Submission Regarding the Proposed Dubbo Zirconia Project

The following provides the submission of Taronga Conservation Society Australia (TCSA) in relation to the Environmental Impact Statement for the proposed Dubbo Zirconia Project.

OBLEY ROAD ALIGNMENT INVESTIGATION & INTERSECTION TREATMENT CONCEPT

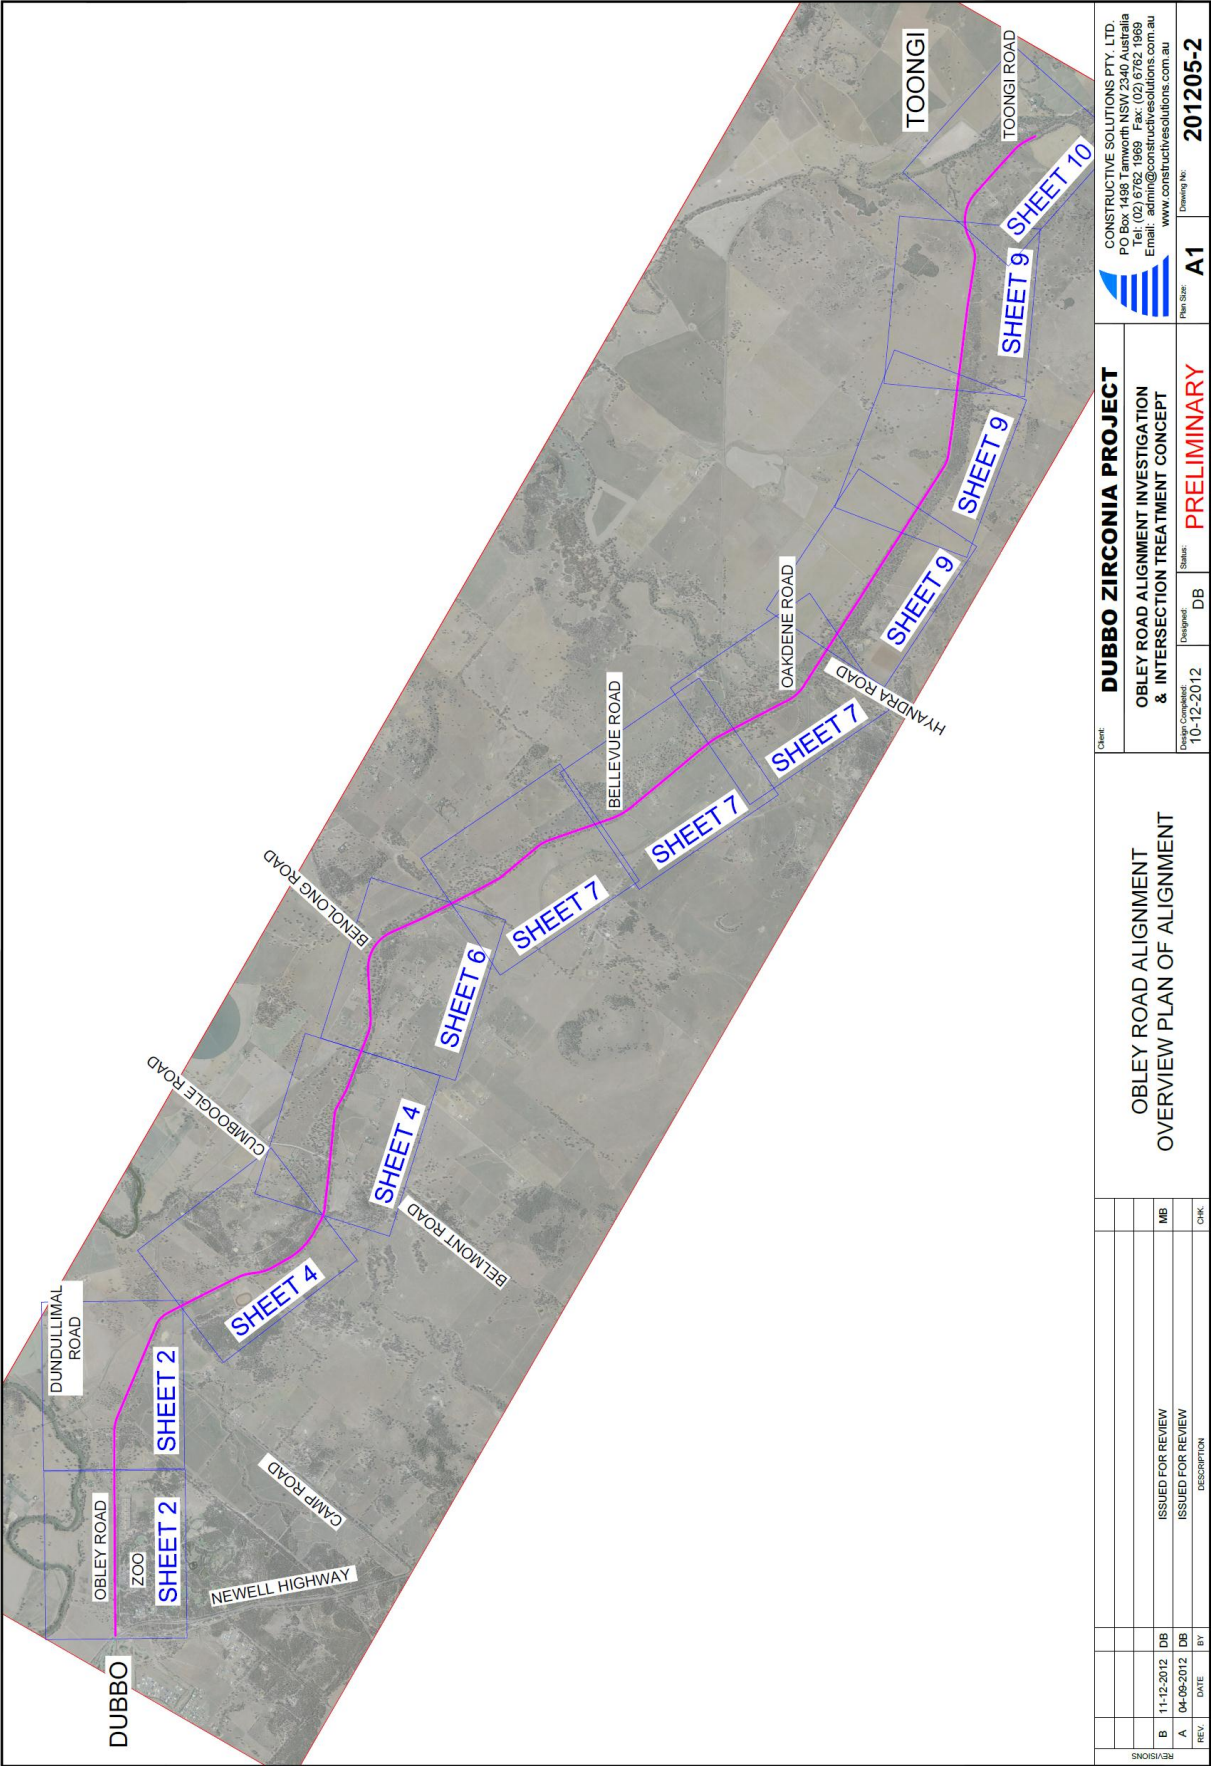
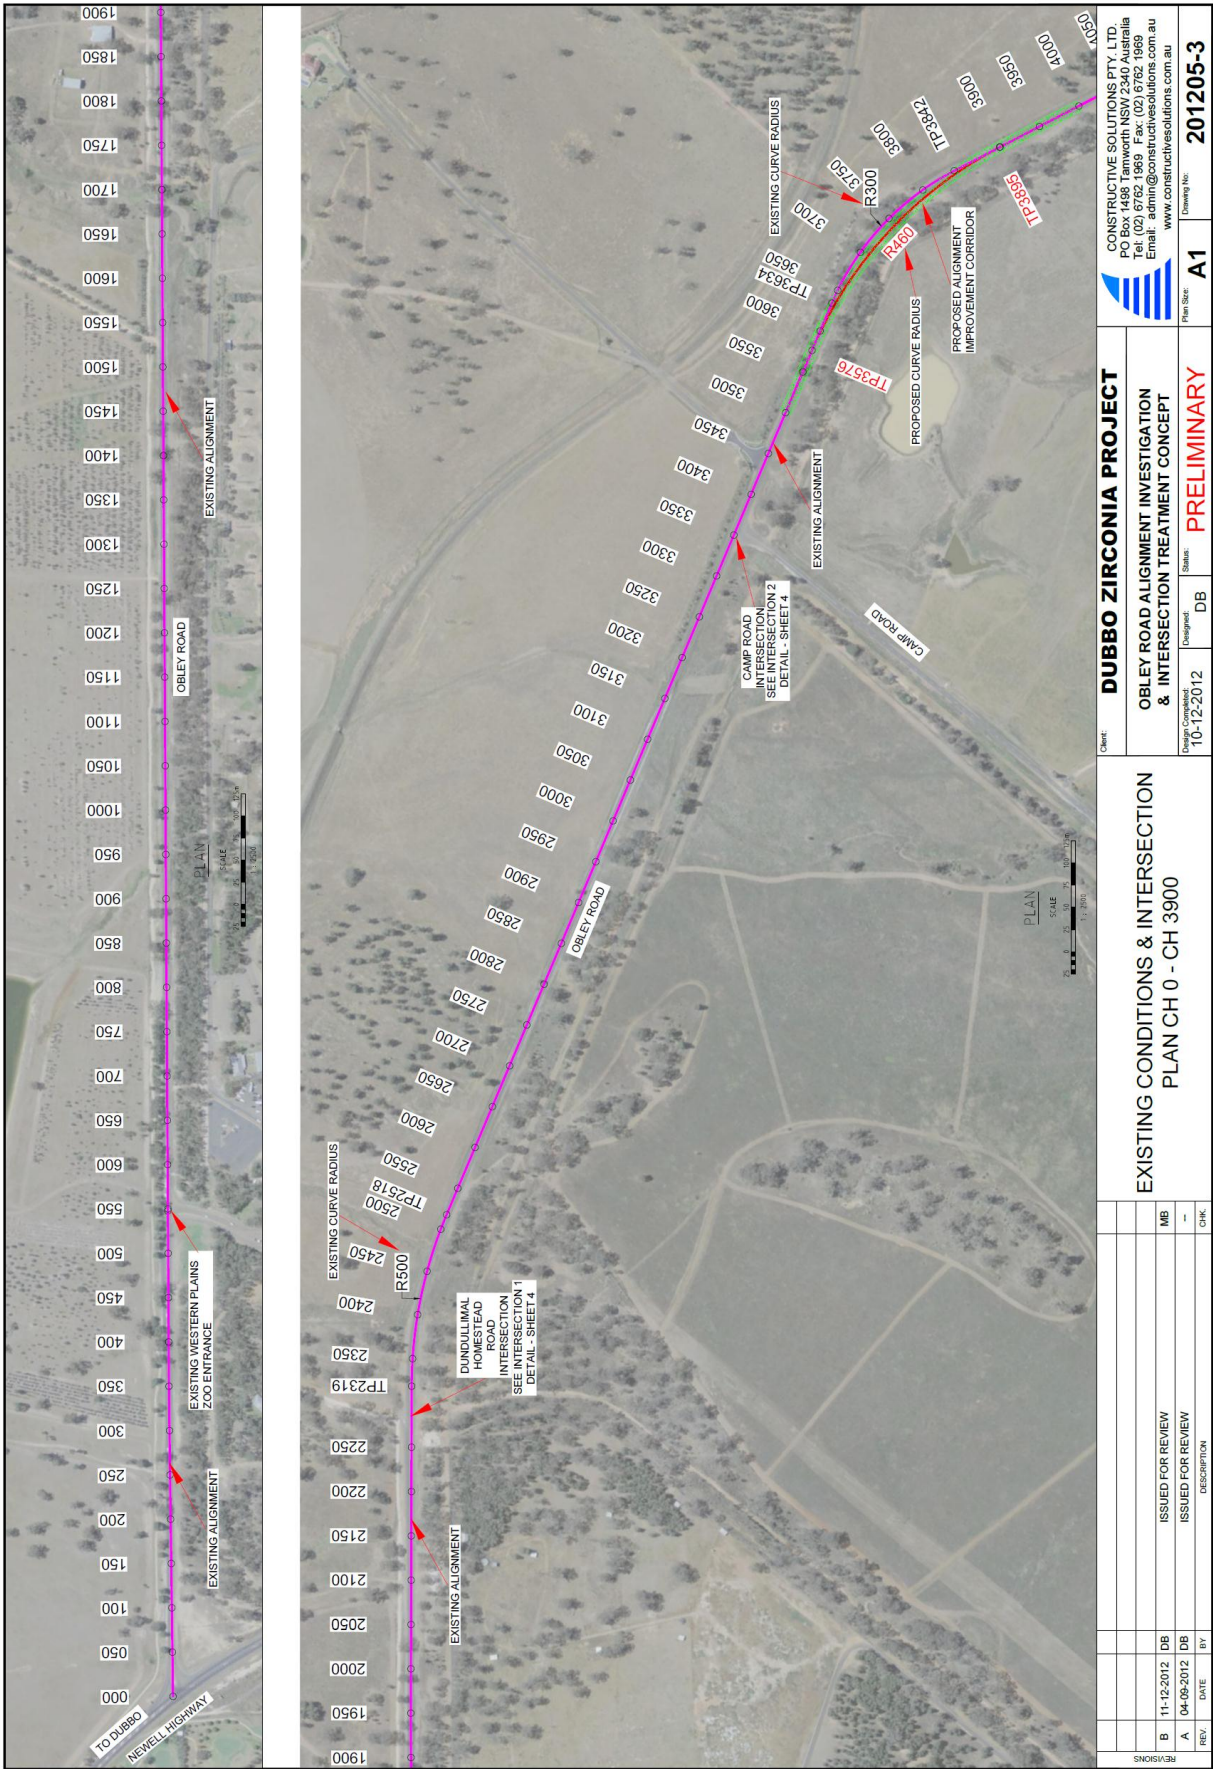
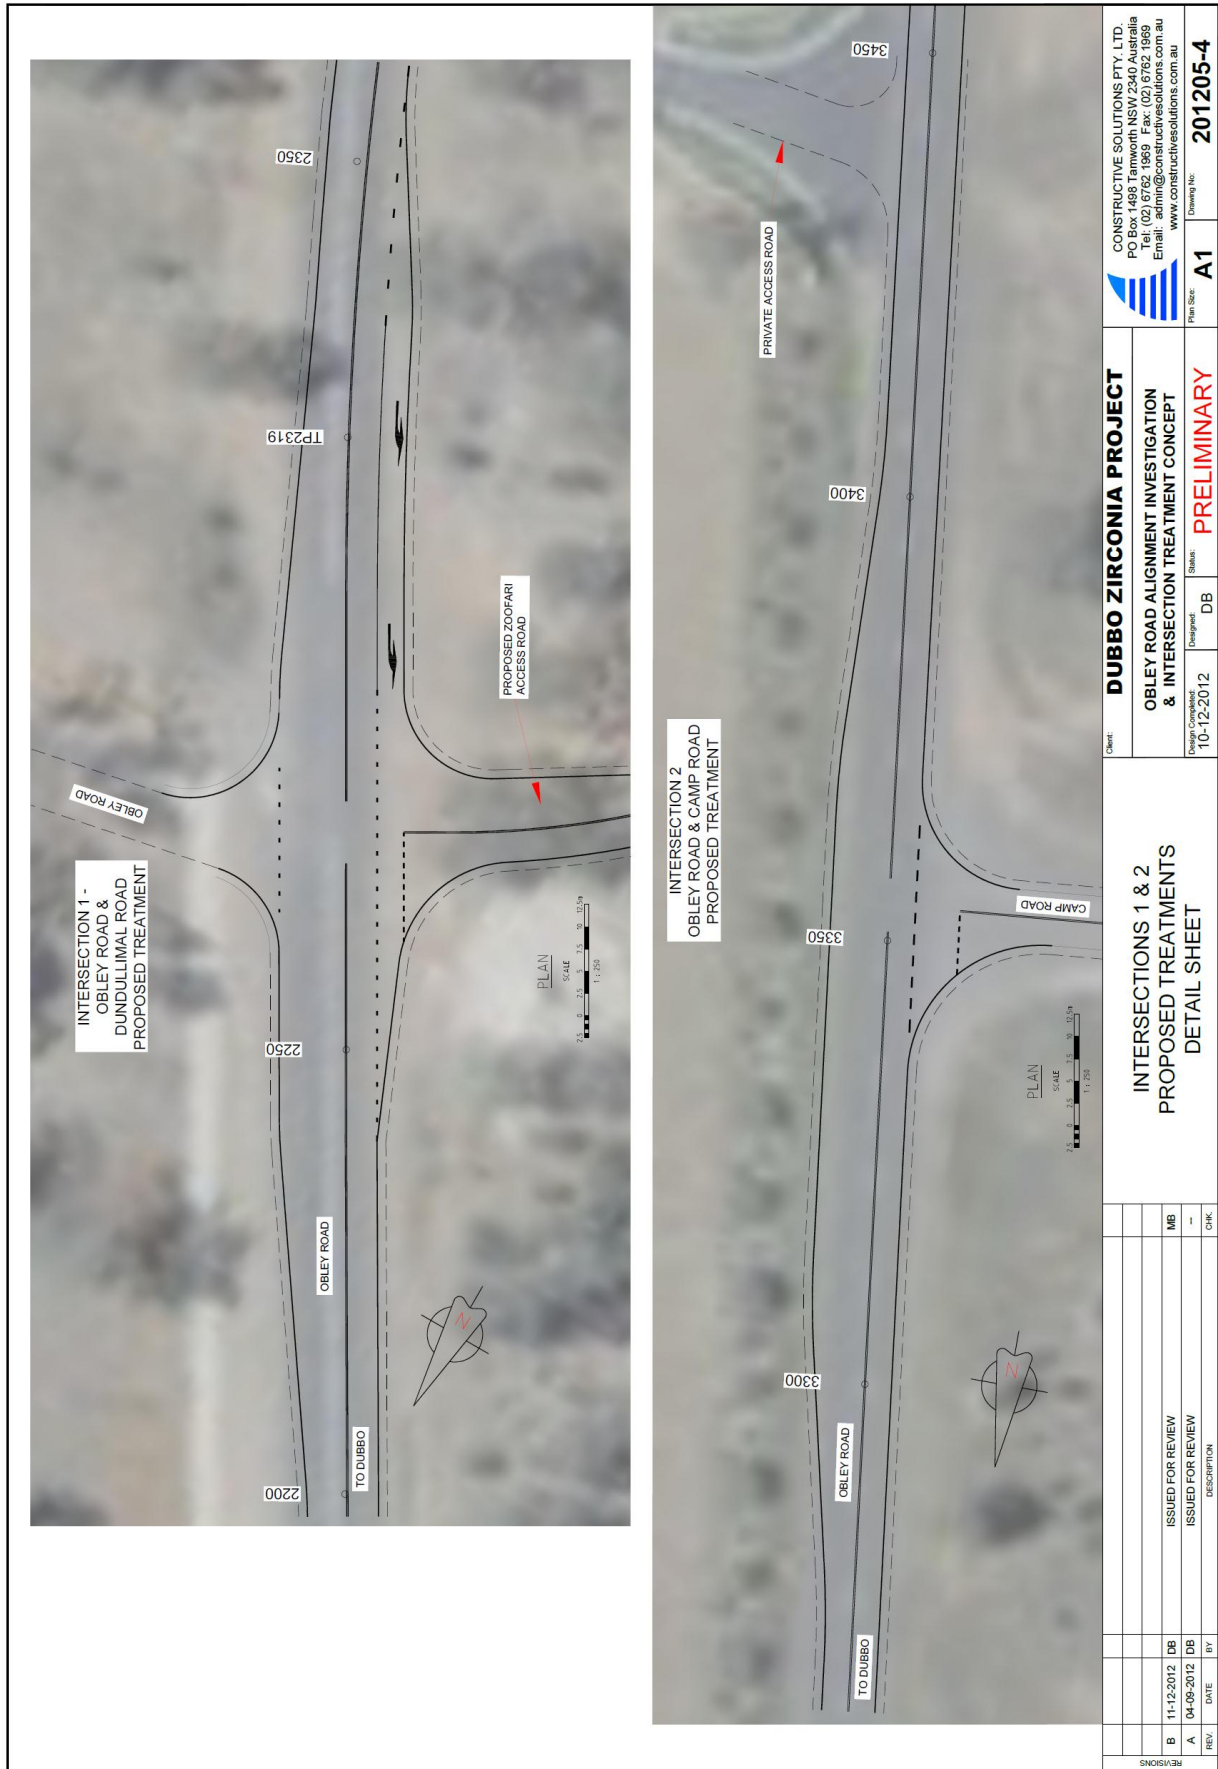
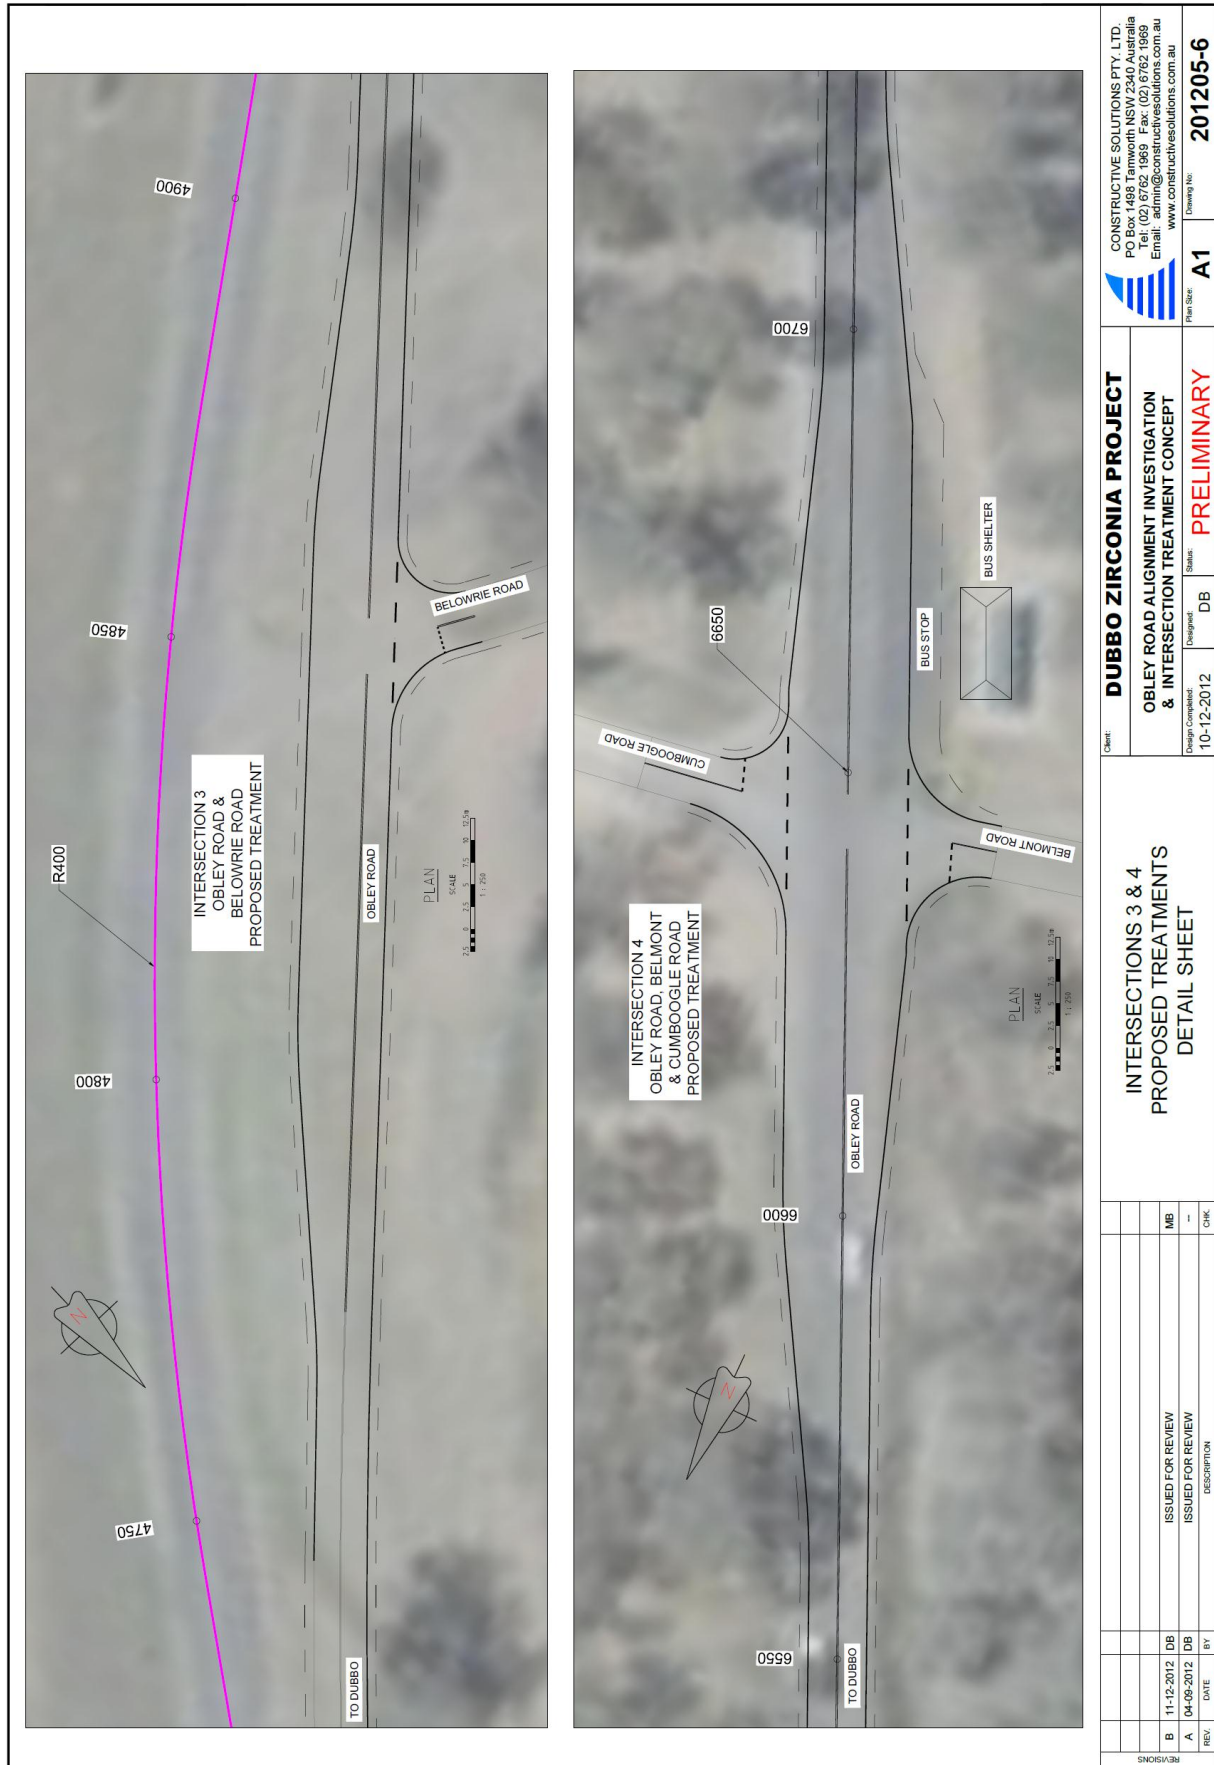
The EIS indicates that there would be various upgrades to Obley Road under the proposal, including alignment adjustments to meet Austroads *Guide to Road Design* requirements for a 100km/hr speed limited road, pavement improvements, and the establishment of a 9m wide pavement seal. No specific improvements to Obley Road adjacent to the main operational area of the zoo, are indicated in Figure 2.4 of the EIS

It will be vital to minimise the risk of conflict between vehicles associated with zoo visitation and those associated with the proposal. TCSA therefore suggests that the standards to be adopted for Obley Road between the Newell Highway and the zoo entrance, should be higher than those adopted for the remainder of Obley Road. Specific improvements requested by TCSA for this section of Obley Road are:

- The establishment of a standard 12m wide road cross section based on Austroads guidelines for roads carrying more than 3000 vehicles per day. This would comprise 2 x 3.5m wide lanes in each direction, 2 x 1.5m wide sealed shoulders, and 2 x 1m unsealed shoulders on the outside of the sealed shoulders.
- Clear road and edge line delineation.
- Addressing the presence of clear zone hazards such as trees (potentially through minor adjustments to the road alignment and/or safety barriers)
- Upgrading of the cyclist/pedestrian crossing on Obley Road near the zoo entrance. The most appropriate solution may be grade-separation

TCSA also requests that pavement upgrades are undertaken along Obley Road between the Newell Highway and Camp Road to create a consistent high quality surface along the entire length of this section of road. We would like consideration to be given to the use of low noise pavement as part of any pavement upgrade.
